Preferred Project Report

North West Precinct Redevelopment (MP10_0166)

Royal Prince Alfred Hospital

Submitted to the Department of Planning and Infrastructure
On Behalf of Health Infrastructure

DEPARTMENT OF PLANNING SUBMISSION
PAVEMENT PLAN

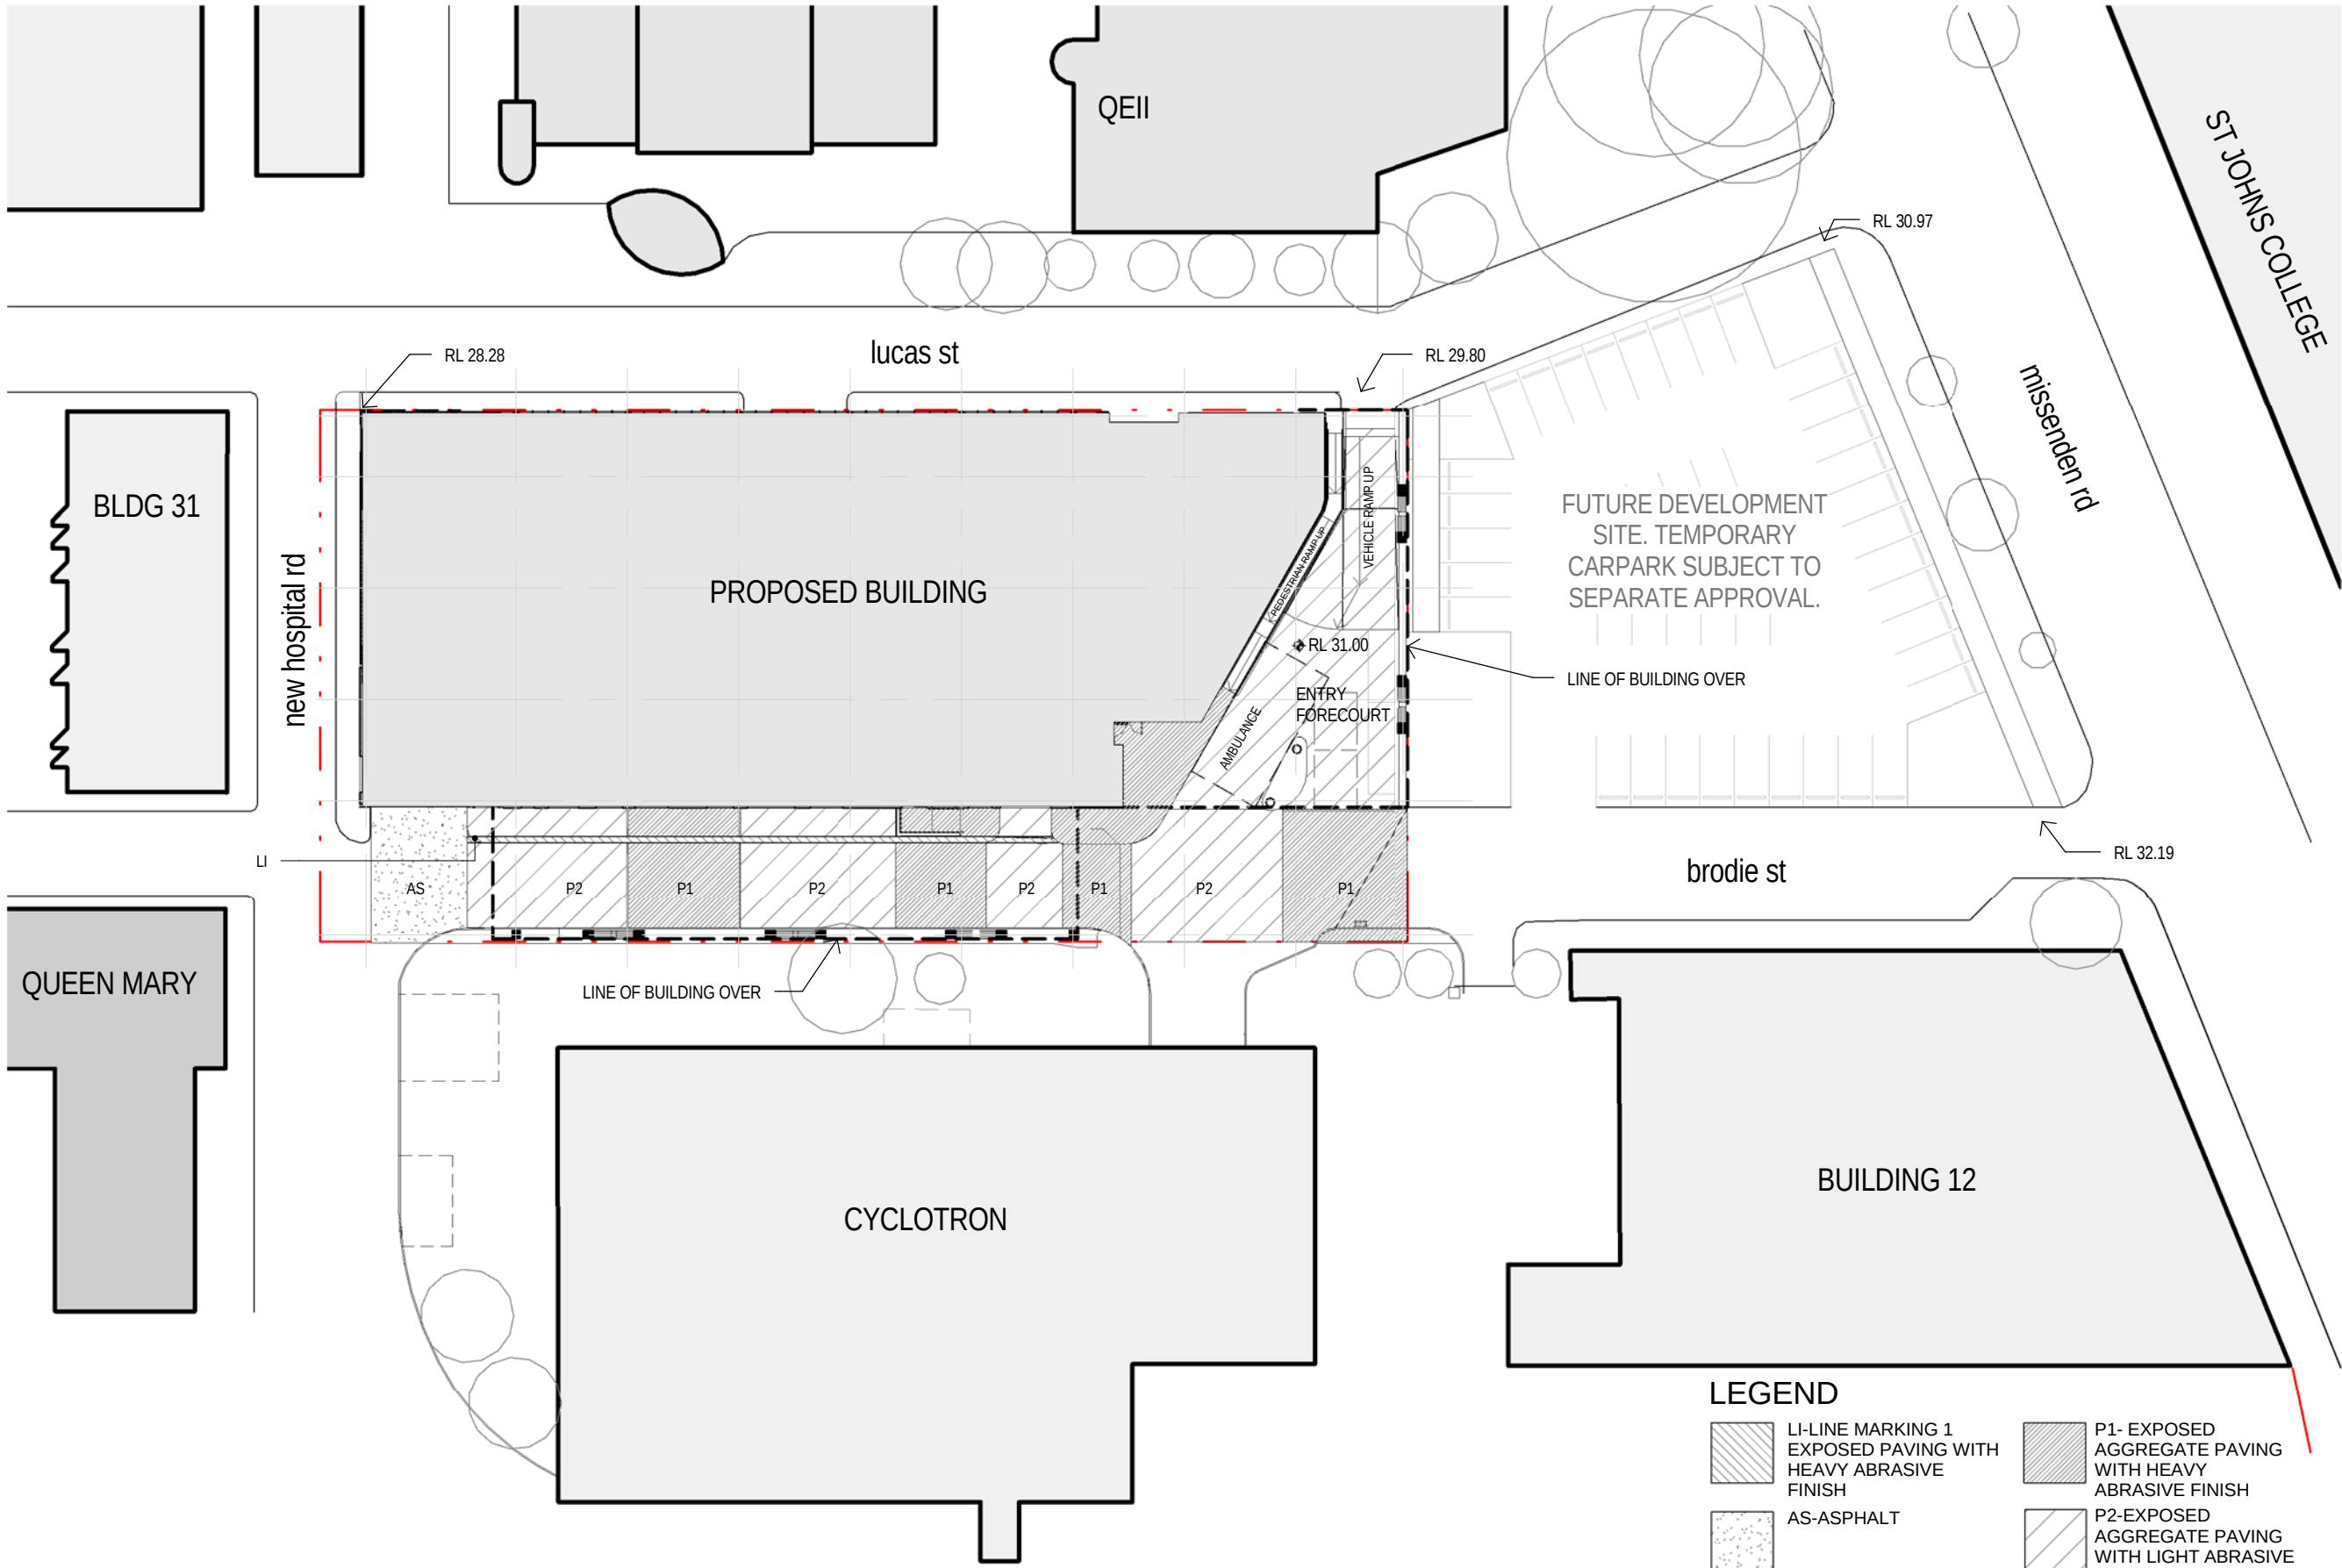
Through the further detailing of pavement materials, levels, and signage the proposed shared zone is now considered by GTA Consultants to be in accordance with relevant requirements outlined by Transport for NSW.

A plan of the proposed pavement is included within the Architectural Drawings prepared by PVH, included within **Attachment 2**.
